Subject: RE: Planning Consultation on: FG/127/20/PL

The surface water drainage scheme has been slightly amended from that approved under FG/48/18/DOC to reflect the revised building footprint, etc. This is acceptable.

Application No: FG/127/20/PL
Registered: 20th October 2020
Site Address: Onslow Caravan Park Onslow Drive Ferring BN12 5RX
Grid Reference: 509207 102977
Description of Works: Retrospective application for the demolition of 3 No. existing buildings & erection of replacement workshop & machinery store building (amended design & siting to FG/37/17/PL). This site is in CIL Zone 5 (Zero Rated) as other development.

DRAINAGE PLAN

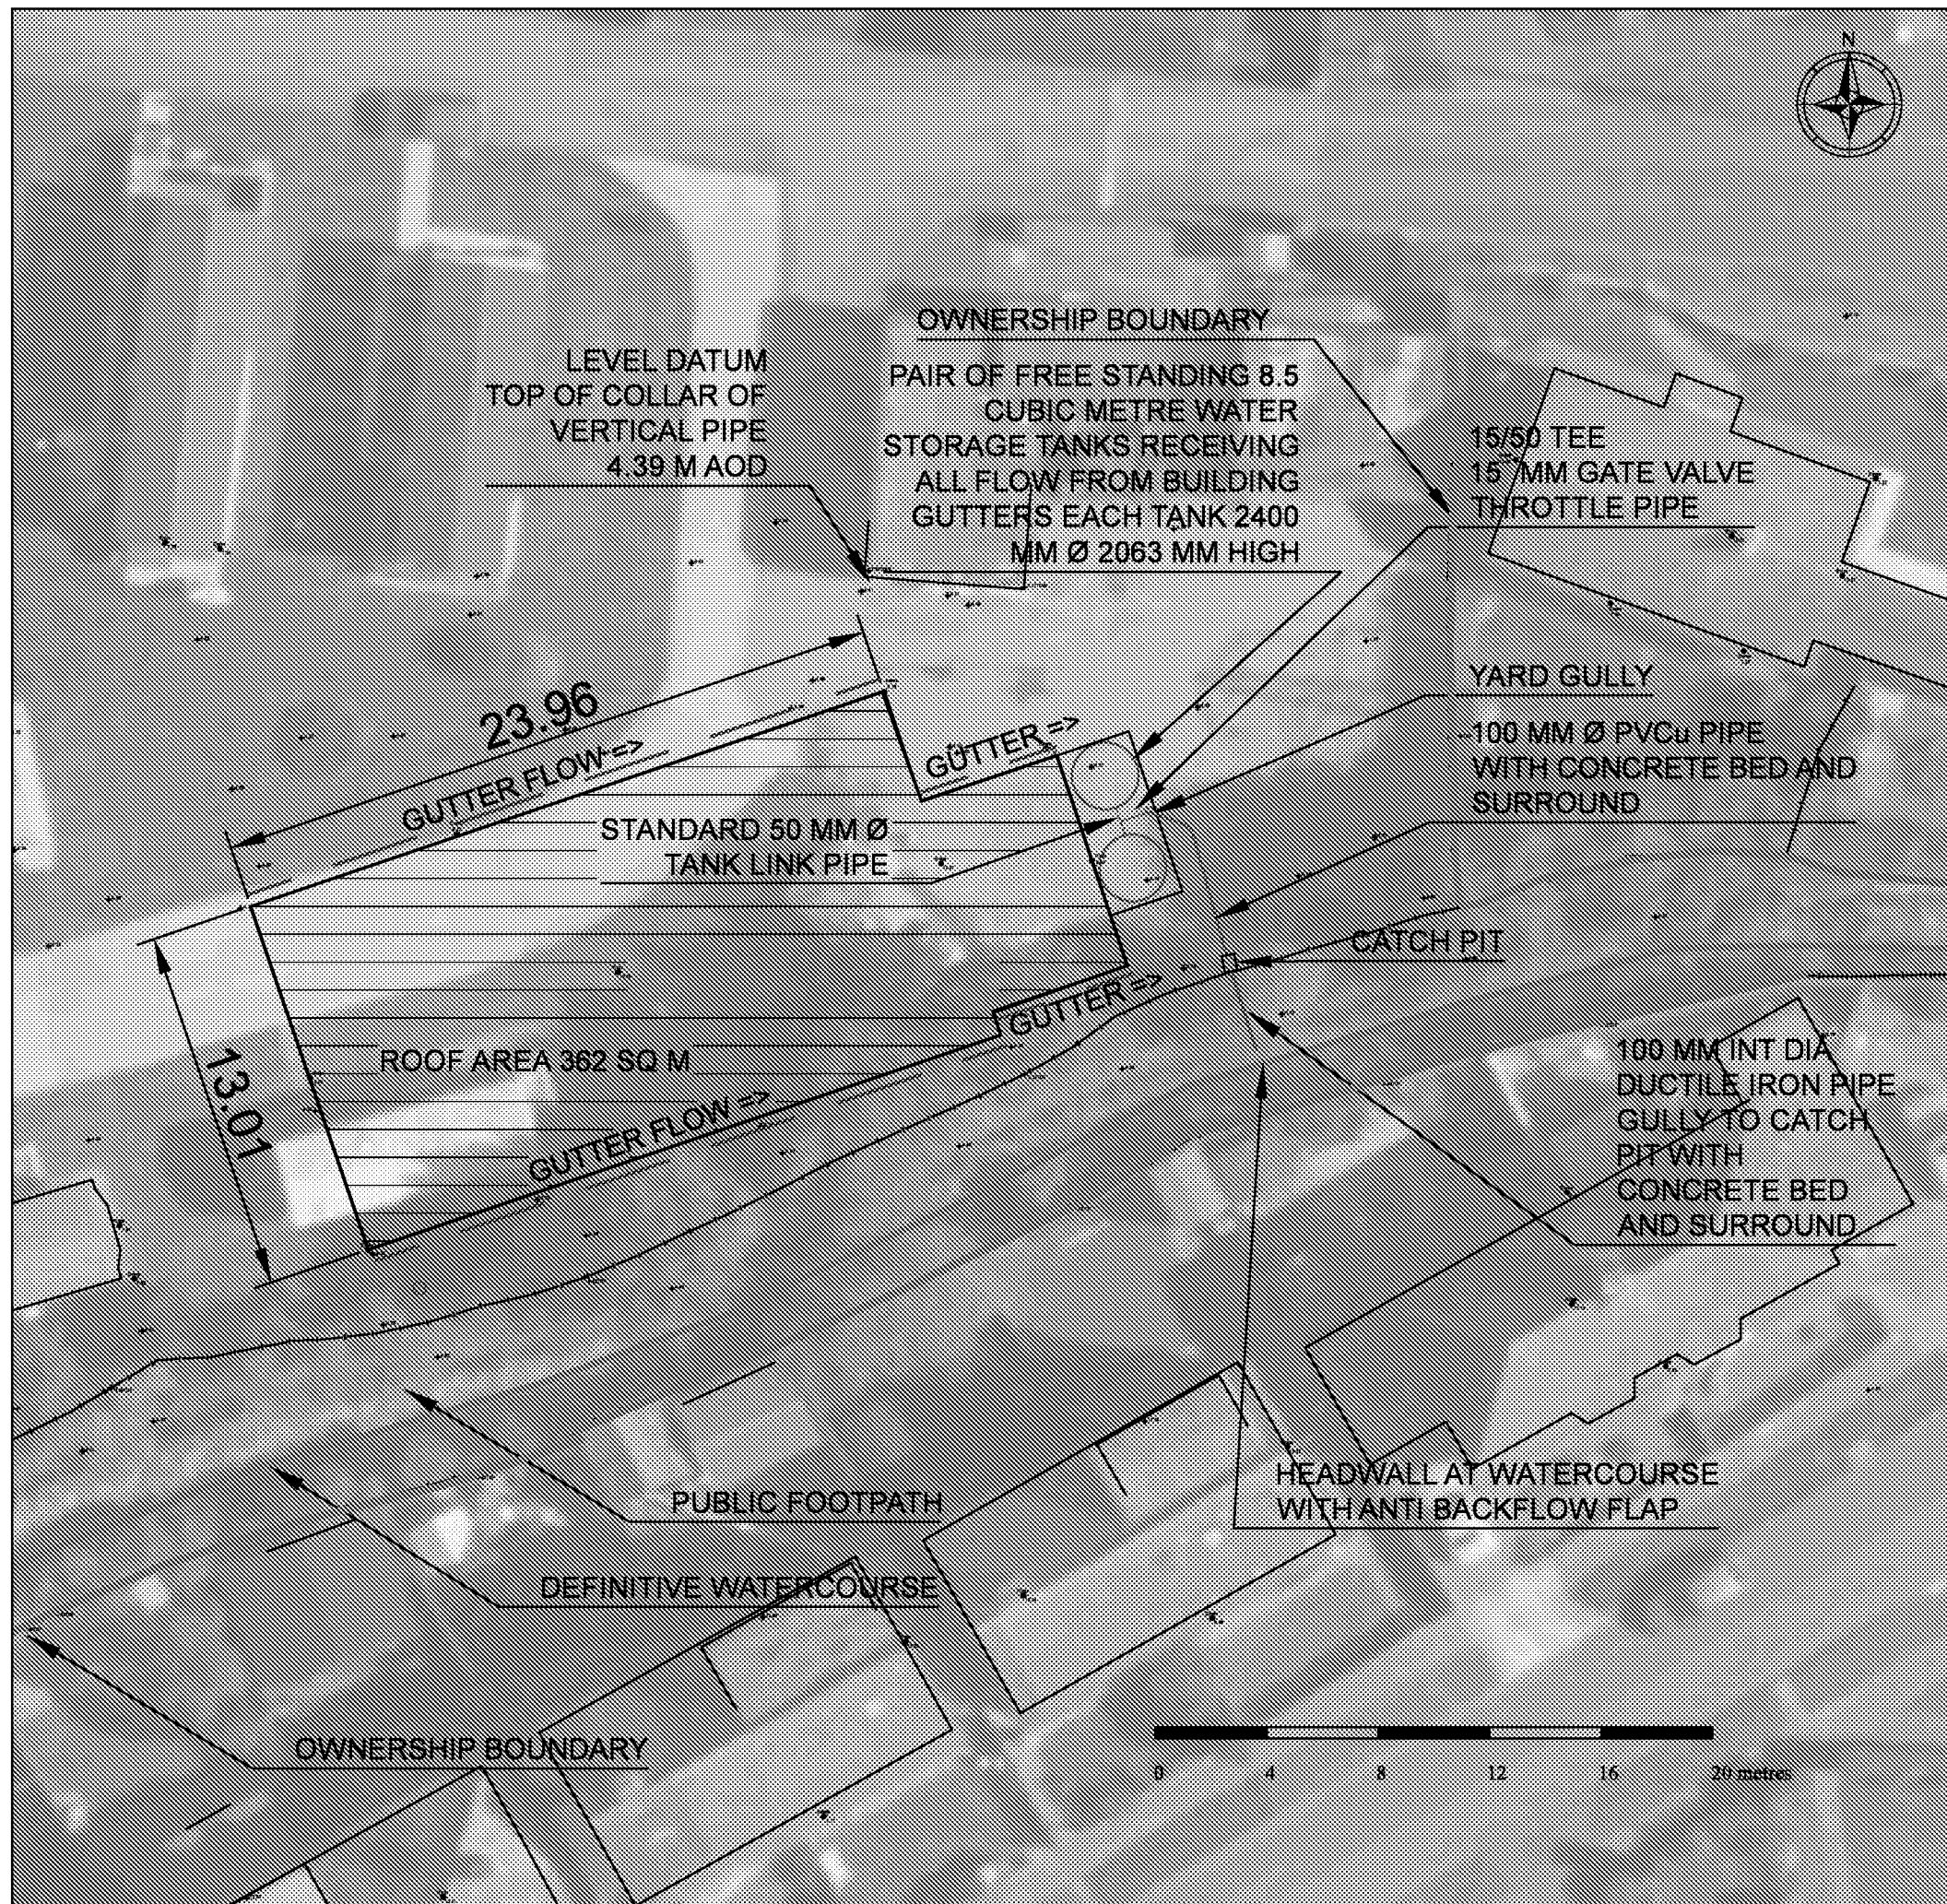
At the time of our last visit to site, it was noted that some of the drainage had been constructed, although the headwall into the ditch required finishing. Please advise the applicant to contact us once the headwall is complete and provide photographs.
